Planning Application Ref: **AW/309/20/T**

Location: **74 Pinehurst Park, Aldwick, PO21 3DZ**

Description of works: **Fell 2No poplar trees (T1 & T2) and remove 1No. dead stump (T3)**

74 Pinehurst Park

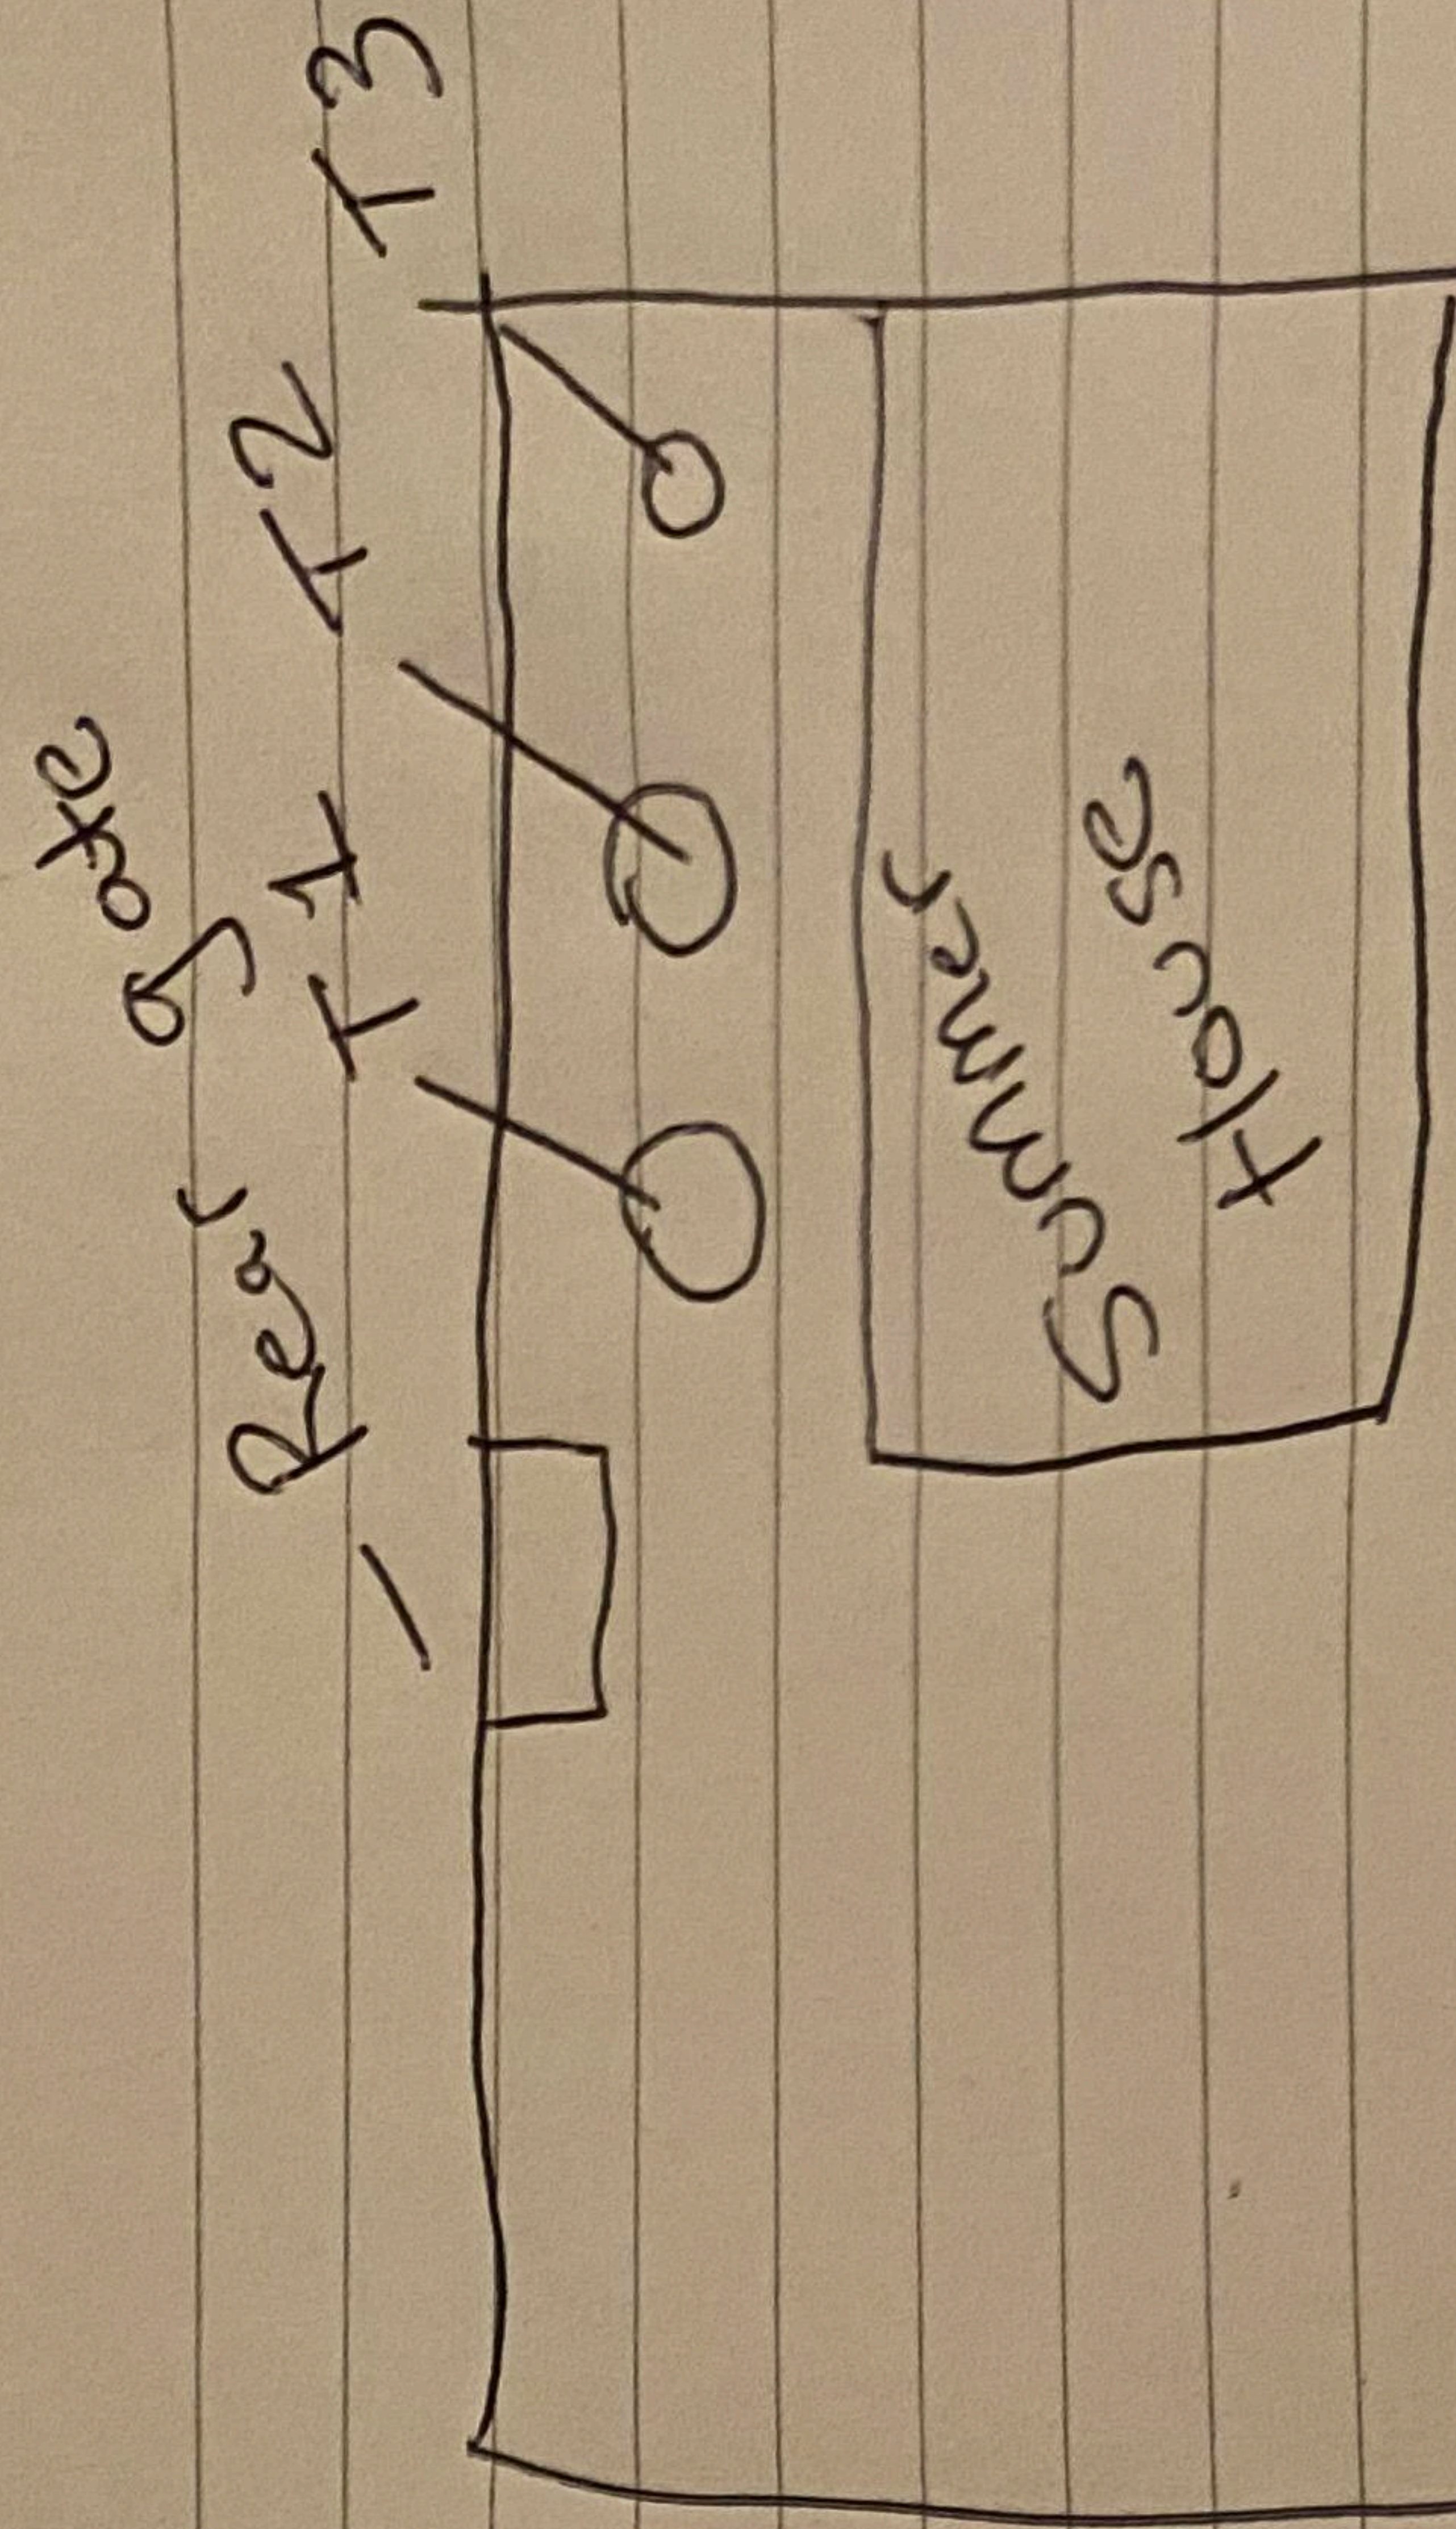
T1 & T2 Lombardy poplar / *Populus nigra Italica* Est. height: 5-10m Radial spread: 0-5m Age class: Early mature

- I have mostly considered this application by means of a desktop review, using the information and plans submitted as well as online resources.
- The applicant has submitted a brief report from a qualified Tree Surgeon in support of the proposal. Significant decay was noted in the main stem of T1 and T2 and there are issues with stability. T3 is a dead poplar stump.
- Although both live trees may have been visually impressive at the time of development, they have been successively lopped in height and much diminished. I note from our records that several companion trees have been removed/failed also since that time. There is a clear gap in the established tree line at this end of Pinehurst Park when viewed from East and West of the property.

- The work proposed is necessary to mitigate risk of structural failure and so justified on arboricultural grounds.
- On completion, this latest proposal ensures the total decline of preserved trees on the rear boundary of the property and corresponding loss of high canopy which had and continues in part to define the character of this estate. As such, there is now a final opportunity to secure a replacement tree of more suitable type that will be both in harmony with the surroundings and provide some environmental and landscape value.

- Once the tree (T1 or T2) has been felled (and either grubbed or ground out) then a replacement tree is to be planted in the same place or elsewhere in the garden and to within 5metres.

This is to be of Standard Nursery Stock proportions (10-12cm girth & 2m to 3m overall height) supported on a 'short stake' system with appropriate securing ties and pads.

It is to be planted within 12 months of the removal of the poplar tree (T1 or T2).
